From: Brenda Larsen
Sent: Wednesday, October 23, 2013 10:22 AM
To: Jeff Watson
Subject: RE: BL-13-00027 Widner

Re: Widner (BL-13-00027)

After conducting a review of the above named project, I have the following comments:

PROPOSED

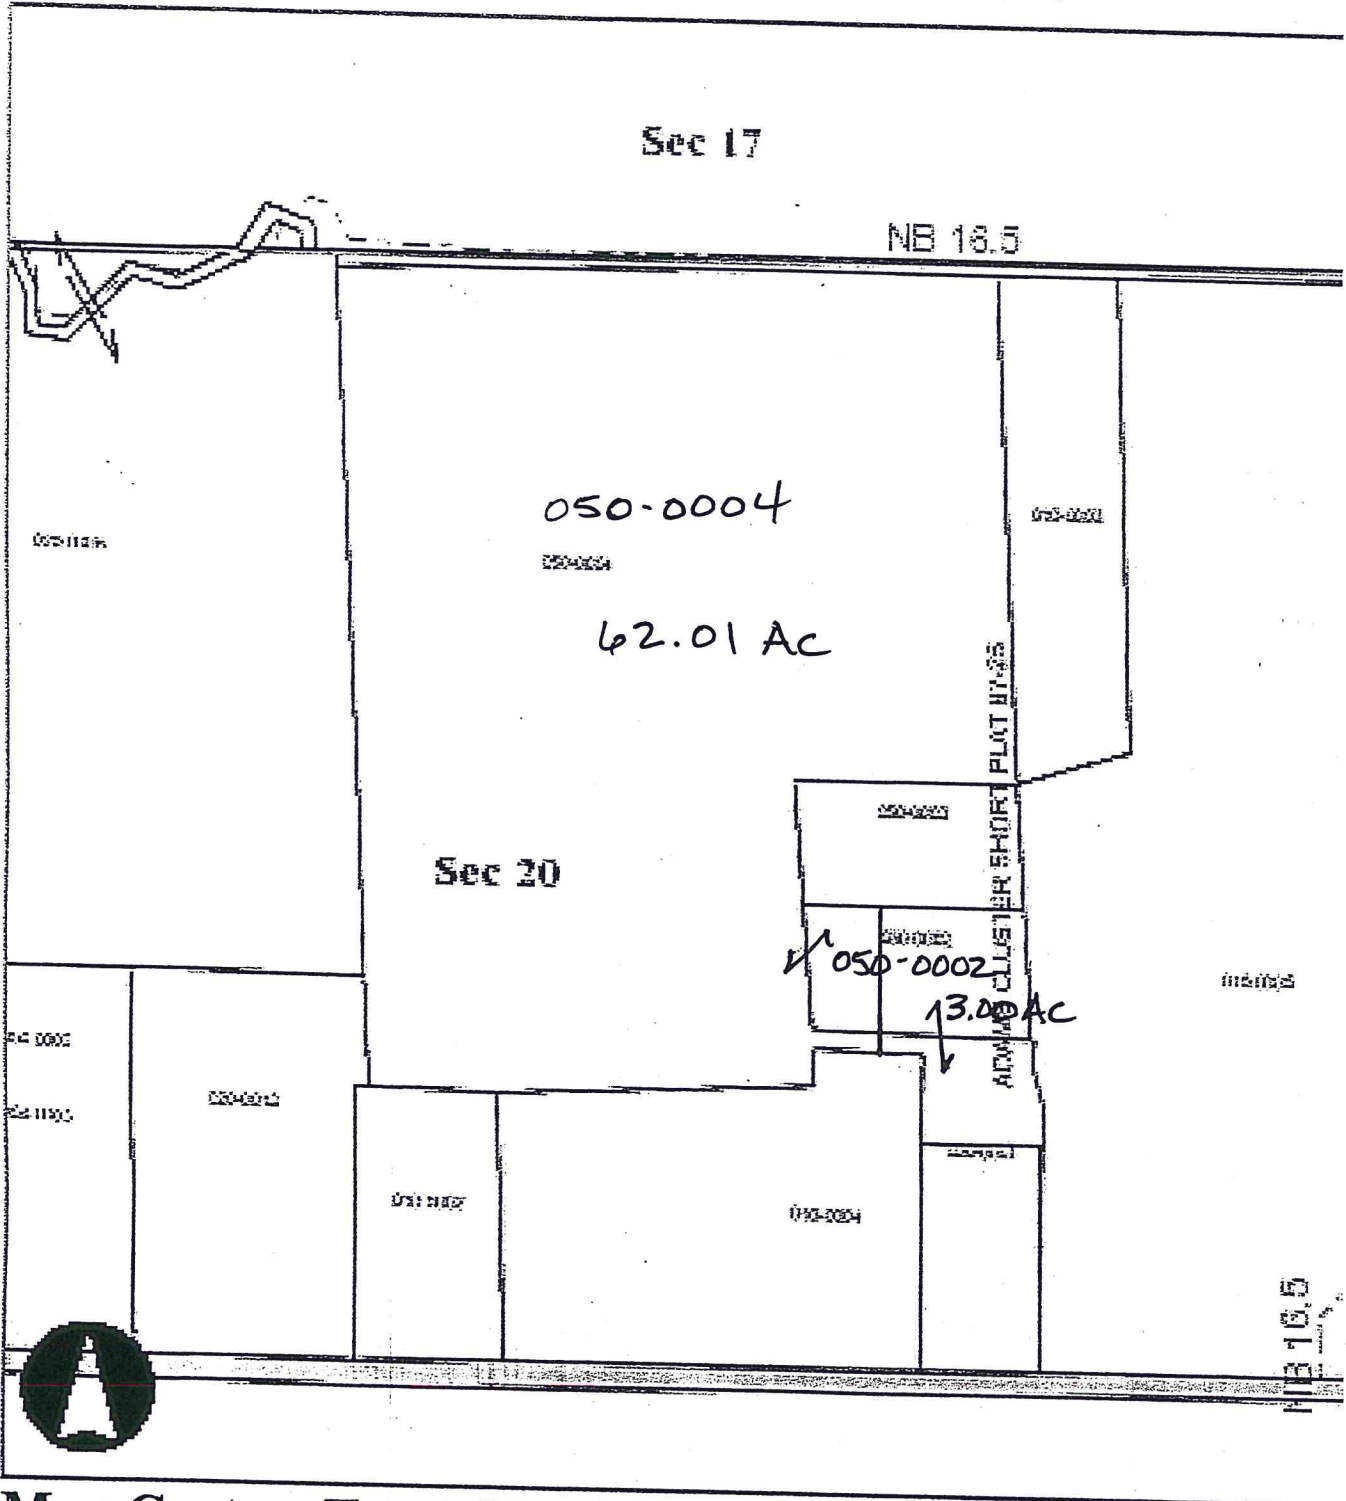
- Ensure that boundary line adjustments do not infringe upon existing structures, to include propane tanks, etc.
- Ensure adequate access for fire apparatus. Any driveways or access points created based off the new lot configurations shall comply with Kittitas County Code 20.02.030.
- All future development must comply with the International Fire Code.
